Annex 1 – Oxfordshire County Council’s response to Cherwell District Council’s consultation dated 14 March 2011 on AMENDED application for Phase One North West Bicester Eco-town (no: 10/01780/HYBRID): Detailed comments

2. Social and Community Infrastructure: Proposed School Site

3. Transport

Figure 5.3

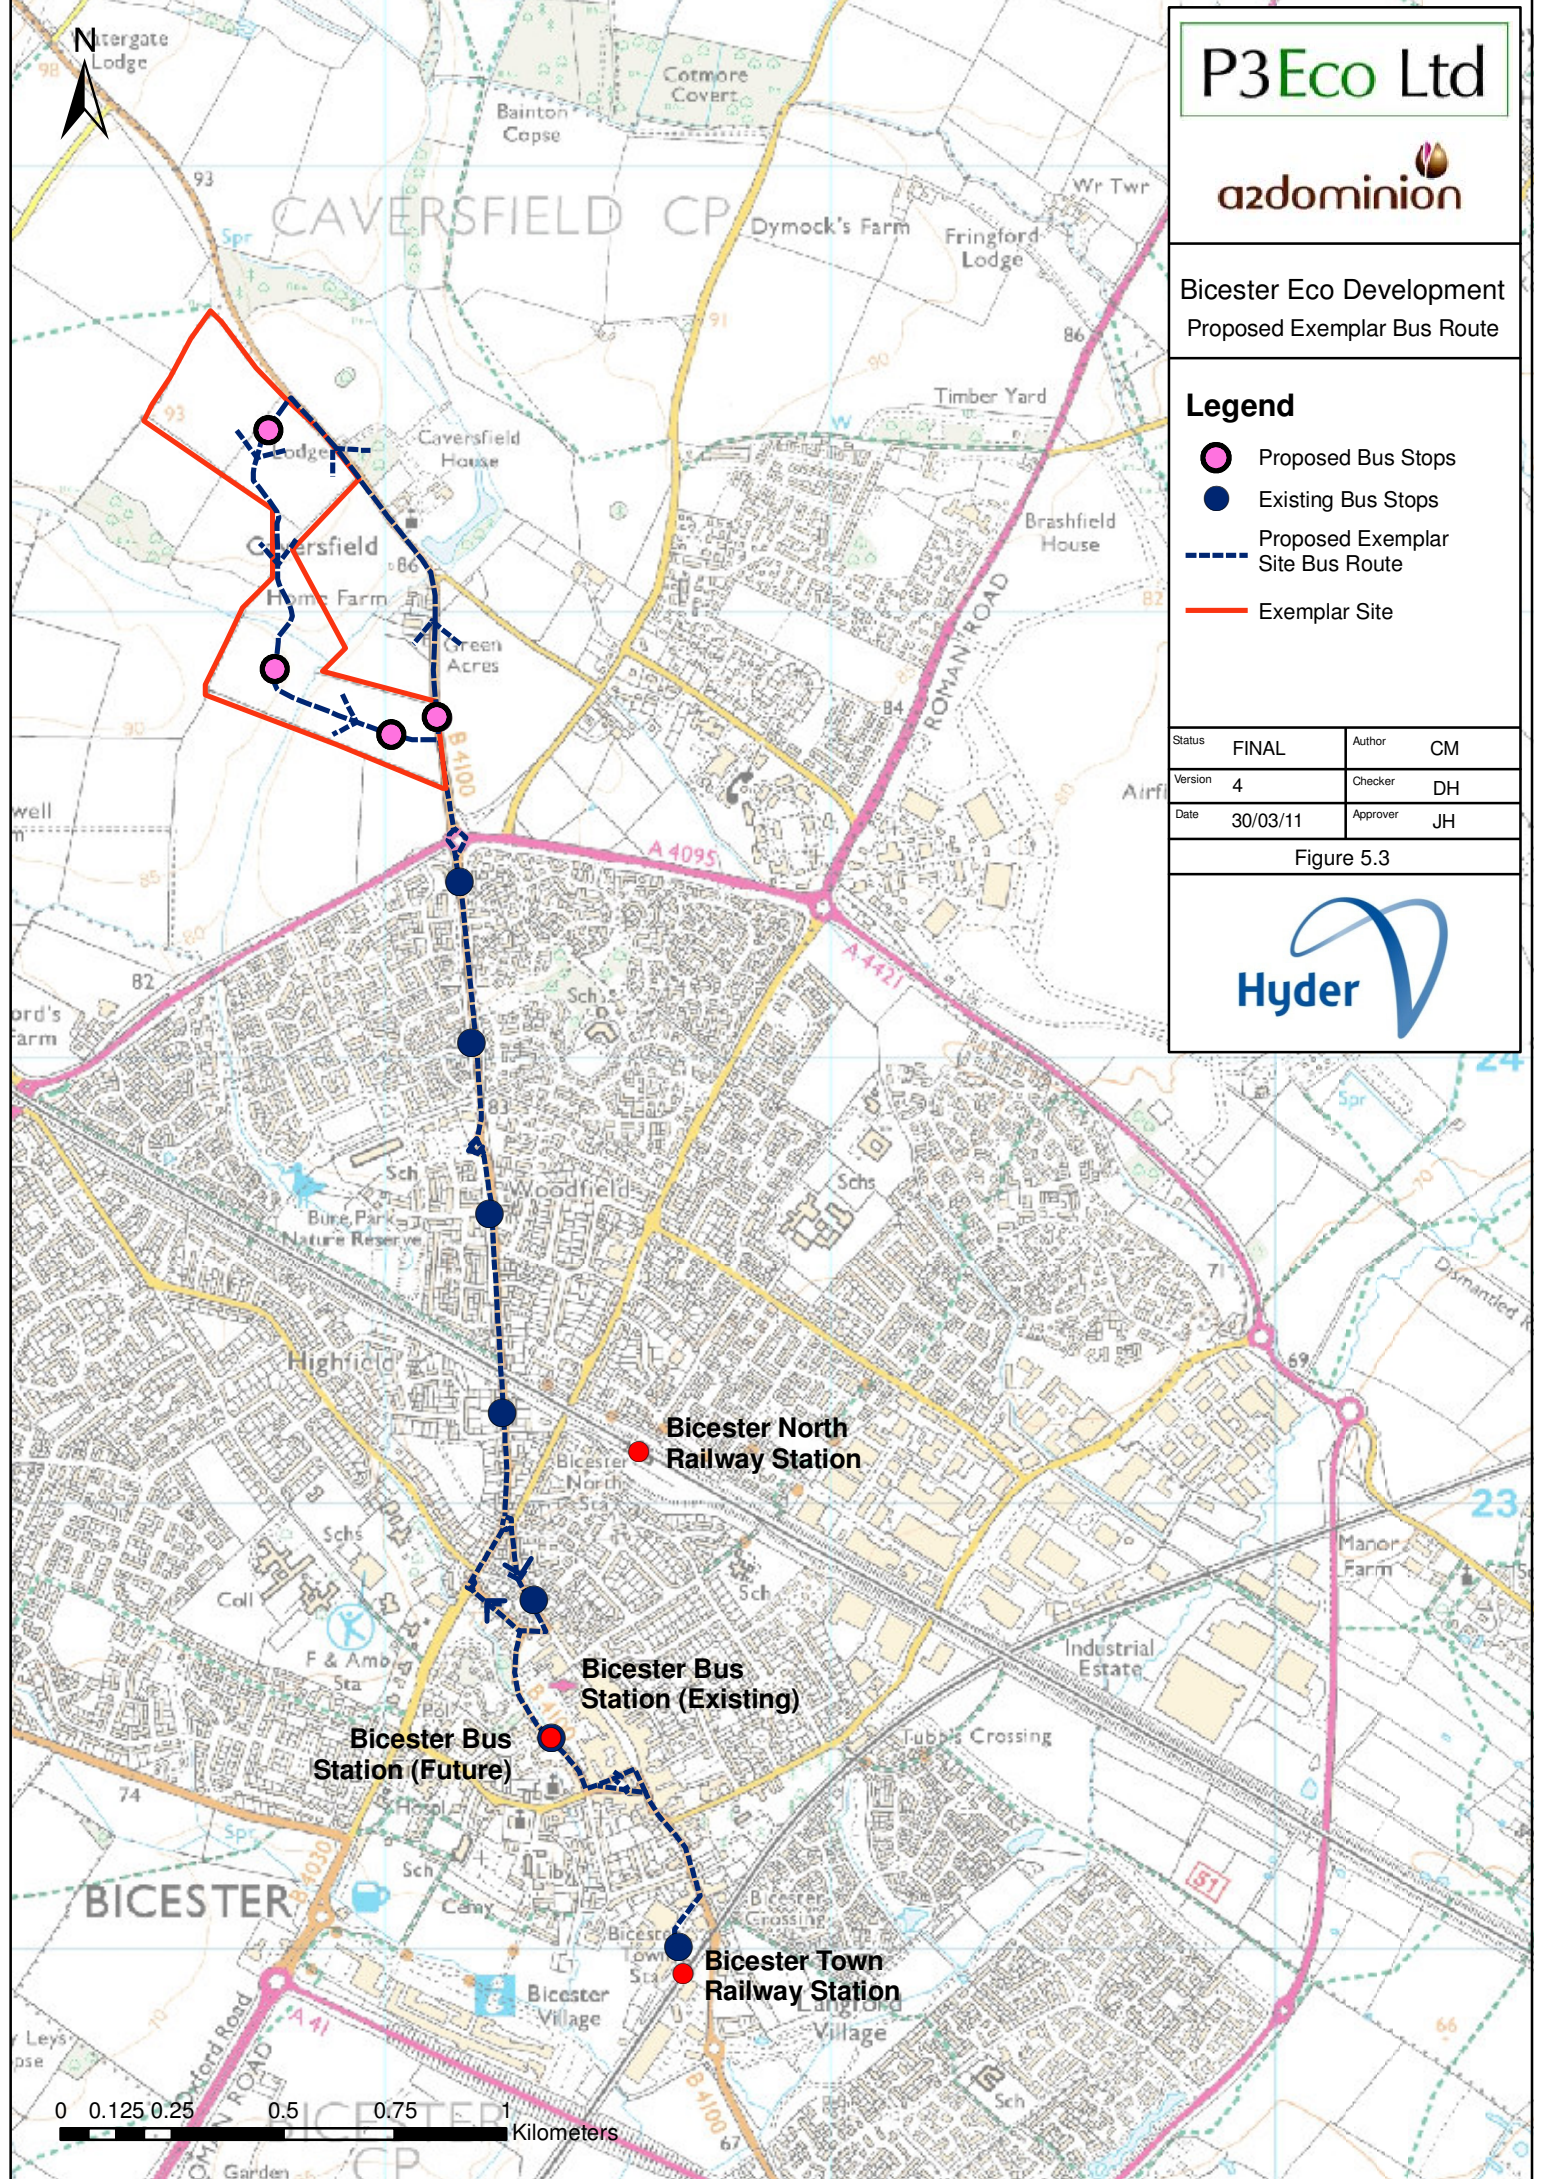
Figures 5.2, 5.3 and 5.4 show a bus stop outside the eco business centre, but it is missing on the South Field Site Plan (BIMP2_PA_03_007 REV C). The bus stop close to the school needs to be moved away from the junction and the bus stop in the northern fields needs moving to connect better with pedestrian movements across the site.
